BCA ASSESSMENT REPORT

60 Wallgrove Road, Eastern Creek

Client: Mirvac

Revision 2

SITE PLAN

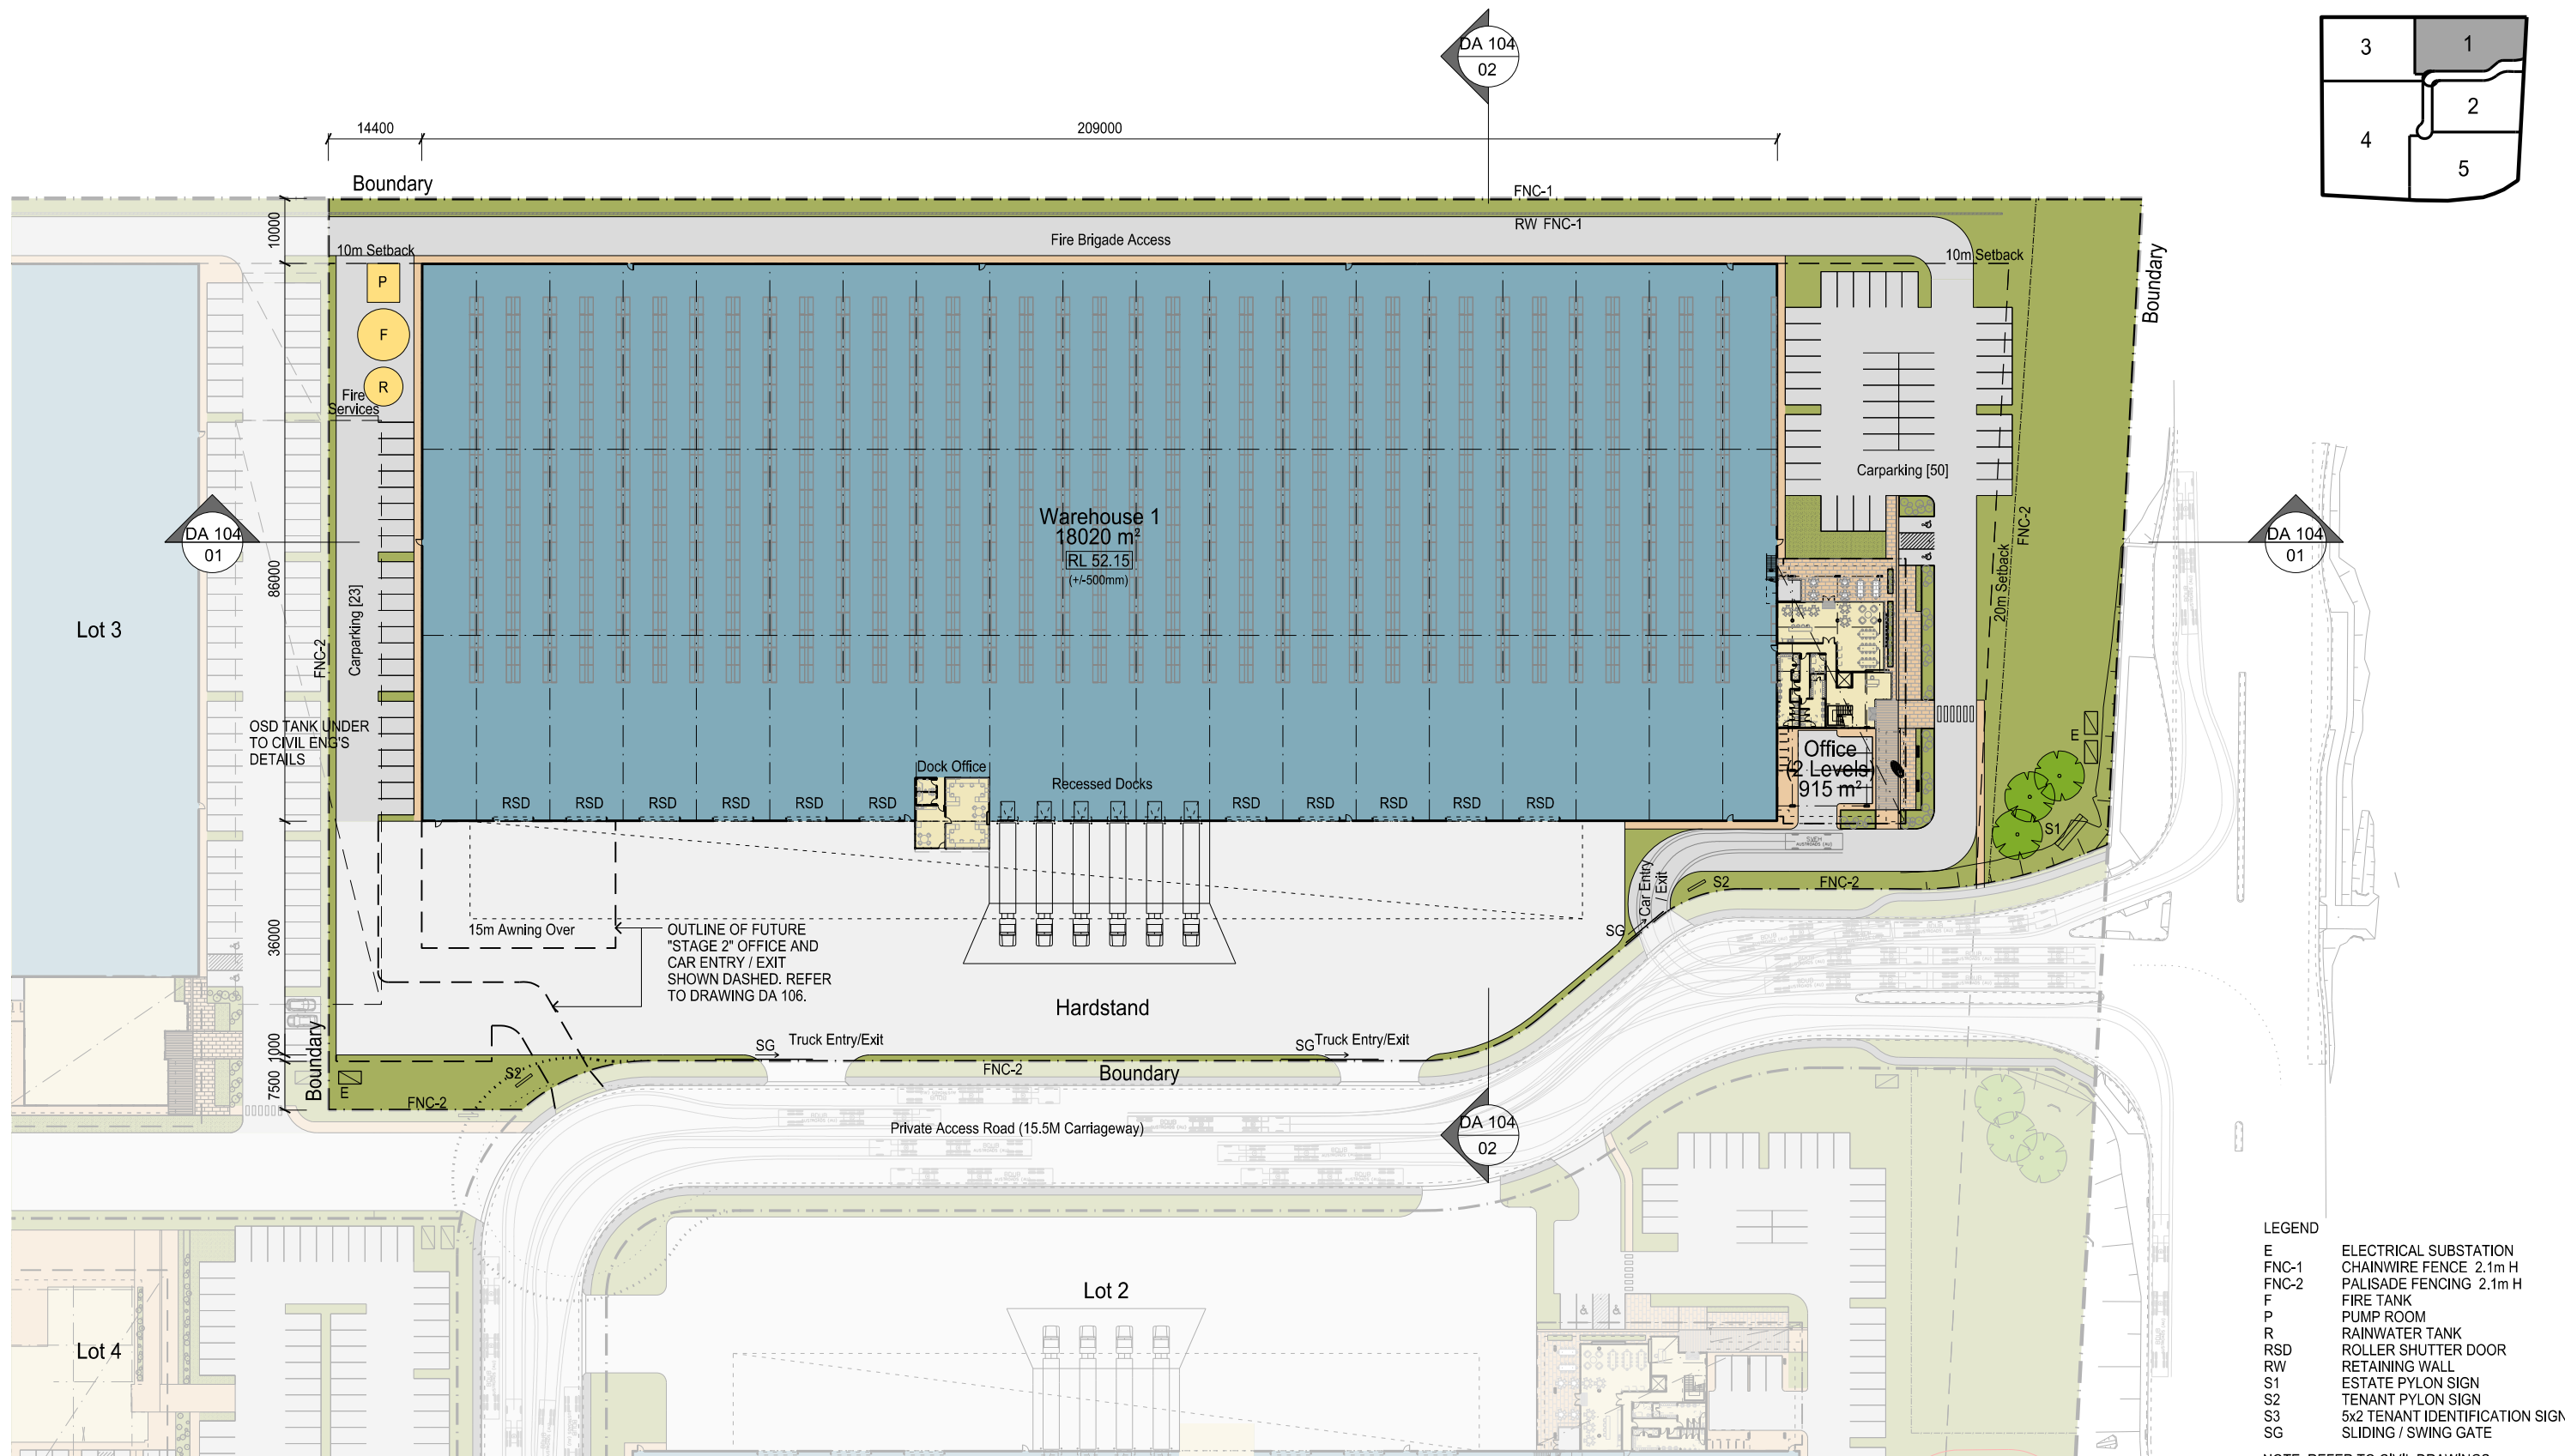
Comments: The proposed warehouse buildings do not comply with the provisions of C2.4 and thus the following non-compliance issues are required to be addressed as an alternative solution by the Fire Safety Engineer to demonstrate compliance with Performance Requirement CP9 - refer to the dot points and the diagram below for details of the proposed non-compliance issues:

- Vehicular Access is greater than 18m from the external wall of Warehouse 1, & 5 – refer to diagram below.

Comments: The exit travel distances in the building are considered to be non-compliant with the requirements of Clause D1.4, in the following areas:

- Warehouse 1 (central areas of the warehouse) – maximum exit travel distances of 65m to an exit.
- Warehouse 2 (central areas of the warehouse) – maximum exit travel distances of 65m to an exit.
- Warehouse 3 (central areas of the warehouse) – maximum exit travel distances of 67m.
- Warehouse 4 (central areas of the warehouse) – maximum exit travel distances of 75m.
- Warehouse 5 (central areas of the warehouse) – maximum exit travel distances of 95m.

Comments: The distances between alternative exits are considered non-compliant with the provisions of D1.5, in the following areas:

- Warehouse 1 - maximum distances between alternative exits of 130m.
- Warehouse 2 - maximum distances between alternative exits of 130m.
- Warehouse 3 - maximum distances between alternative exits of 135m.
- Warehouse 4 - maximum distances between alternative exits of 150m.
- Warehouse 5 - maximum distances between alternative exits of 190m.

The above non-compliance issues are required to be addressed as an alternative solution by the Fire Safety Engineer to demonstrate compliance with Performance Requirements DP4 & EP2.2.

The above non-compliance issues are required to be addressed as an alternative solution by the Fire Safety Engineer to demonstrate compliance with Performance Requirements DP4 & EP2.2.
